Rezoning Transportation Analysis

Petition Number: 2025-048

General Location Identifier: 03703101

Date	Description
5-28-25	First Review (IW/KC)
7-23-25	Second Review (IW/KC)
8-26-25	Third Review (KC) ZC

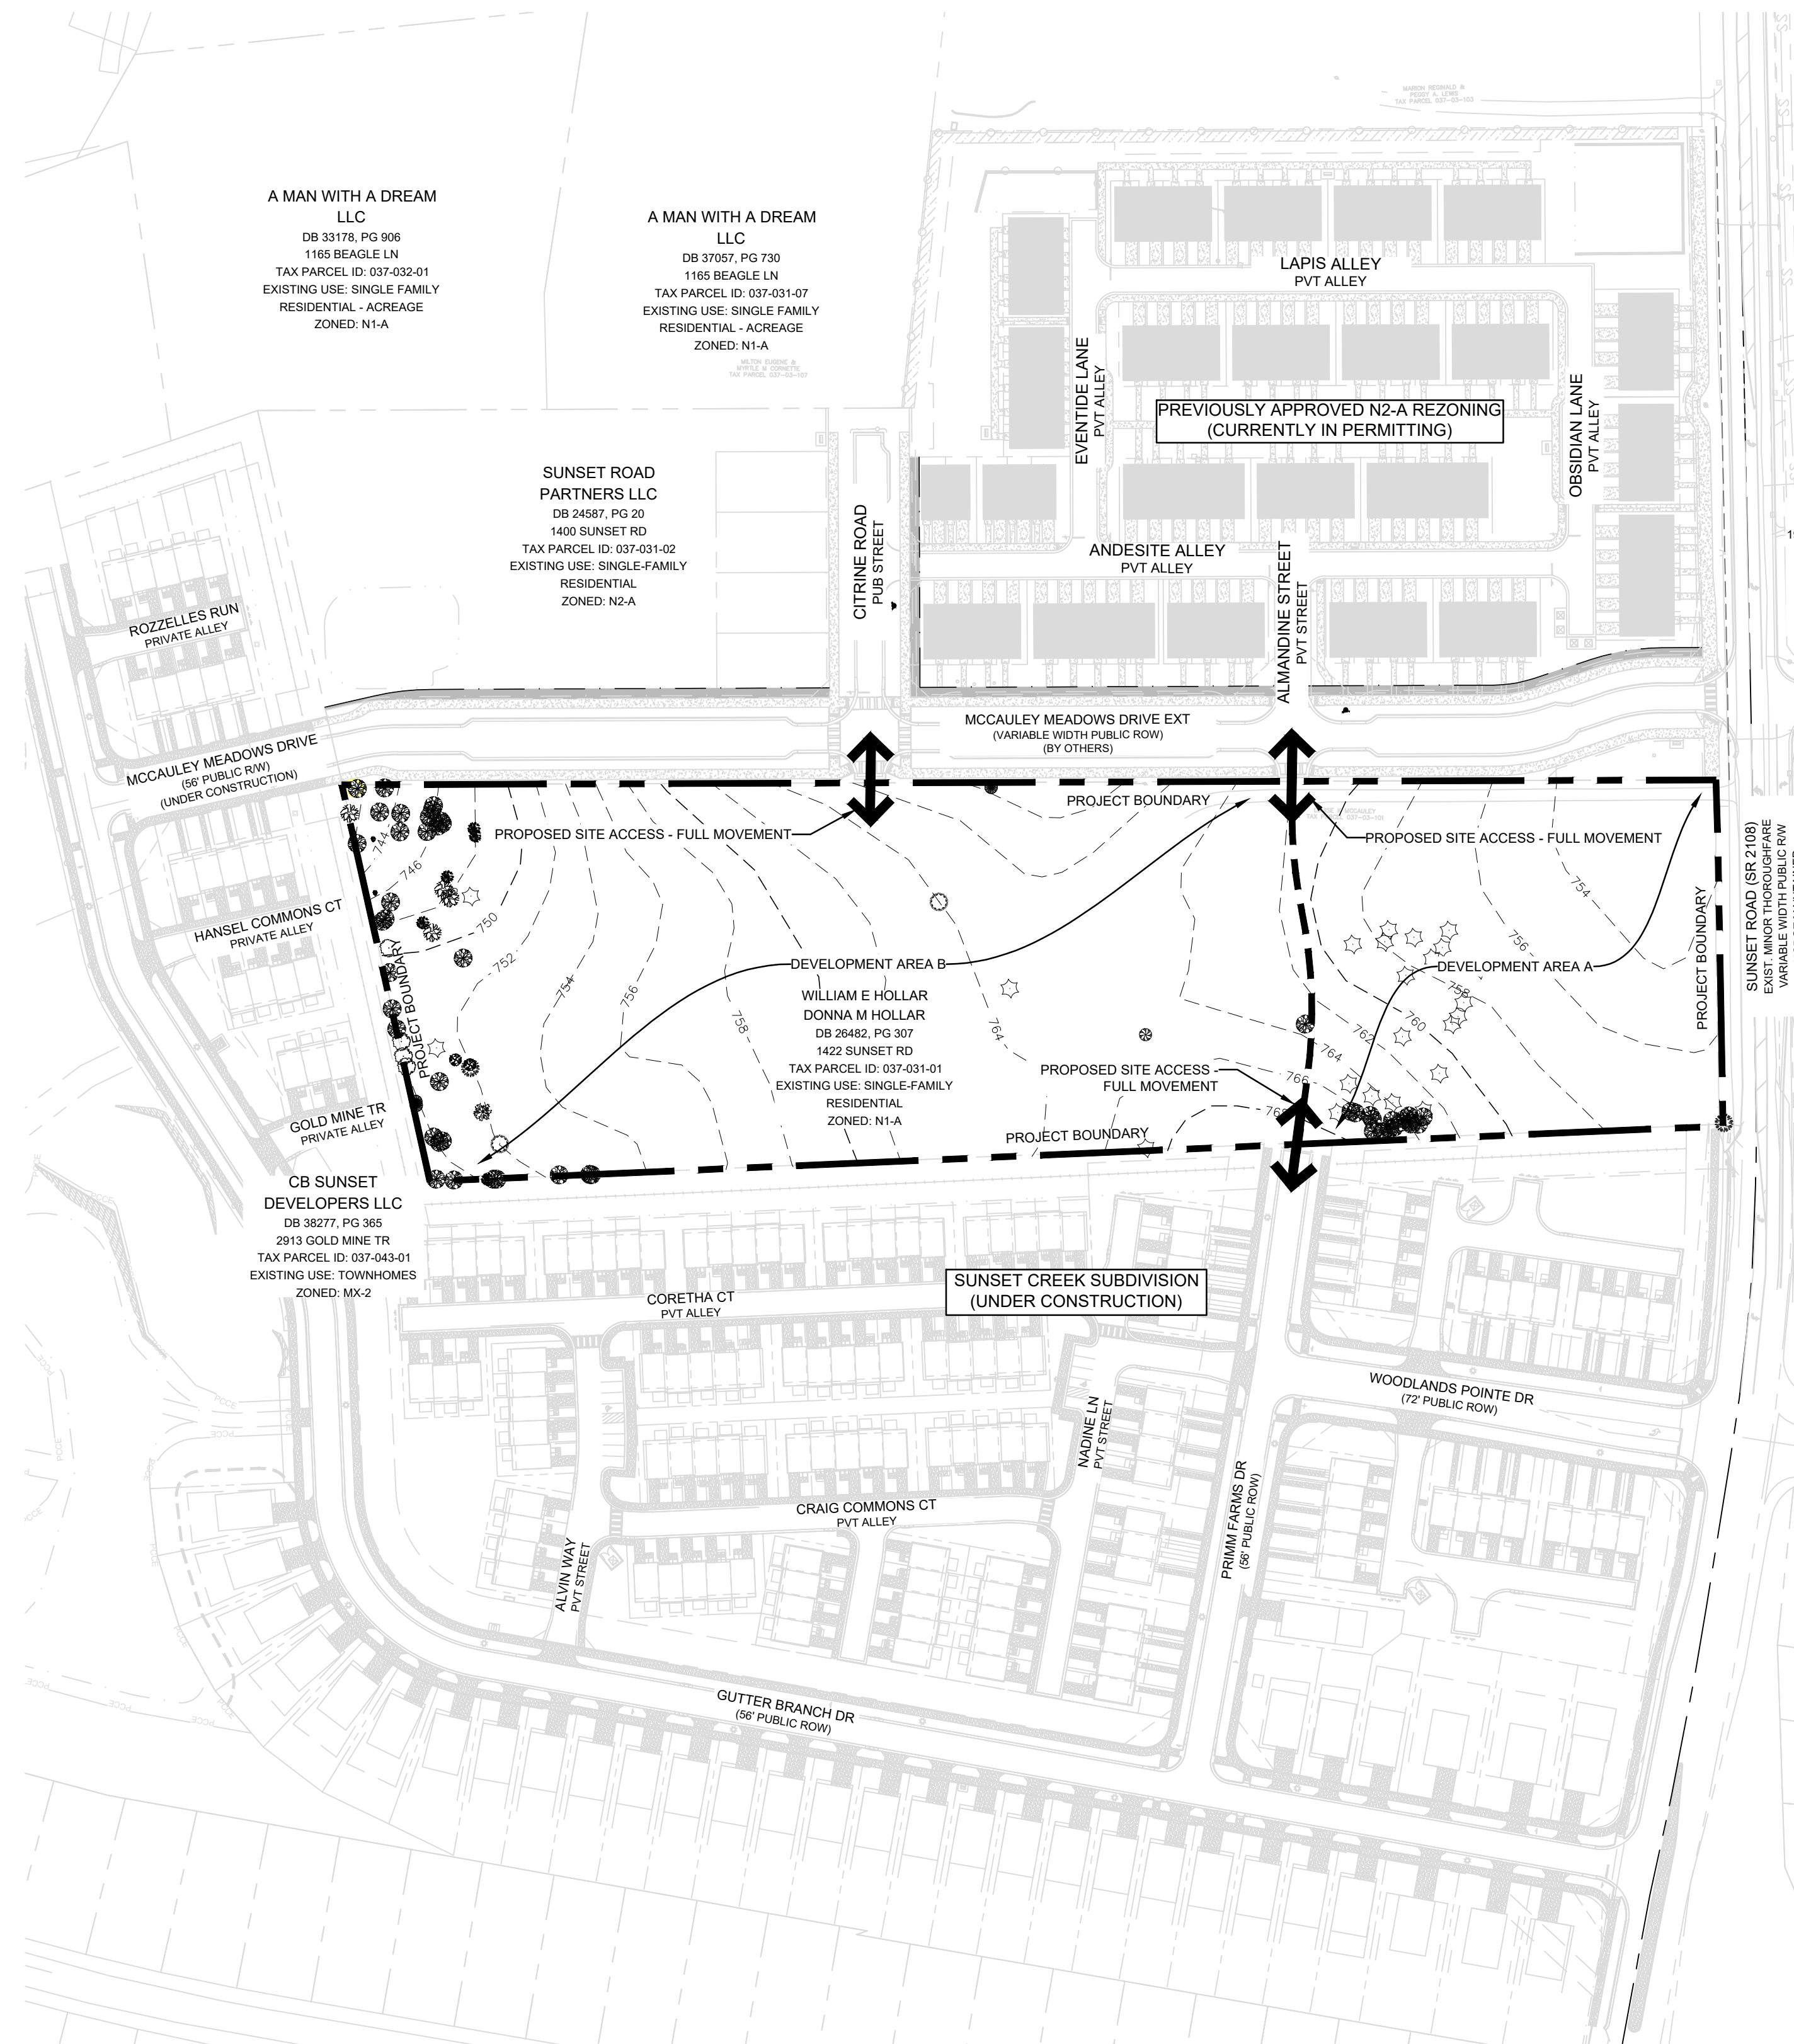
b. **McCauley Meadows Drive:** Location of future curb and gutter is to be installed 17.5' from centerline.

Label and dimension the curb and gutter from the centerline for each road on the site plan.

Clarifying Comment 8/26/25: Label McCauley Meadows Drive as U-03A1 for reference on the site plan.

3. **Outstanding Comment from 5/28/25:** Revise site plan and conditional note(s) to commit to dedicate 33.5' right-of-way from the road centerline along McCauley Meadows Drive and Proposed Public Street. The site plan shall label and dimension the right-of-way from the road centerline.

Clarification: McCauley Drive should show what the future right of way is to be for reference. Label and dimension.
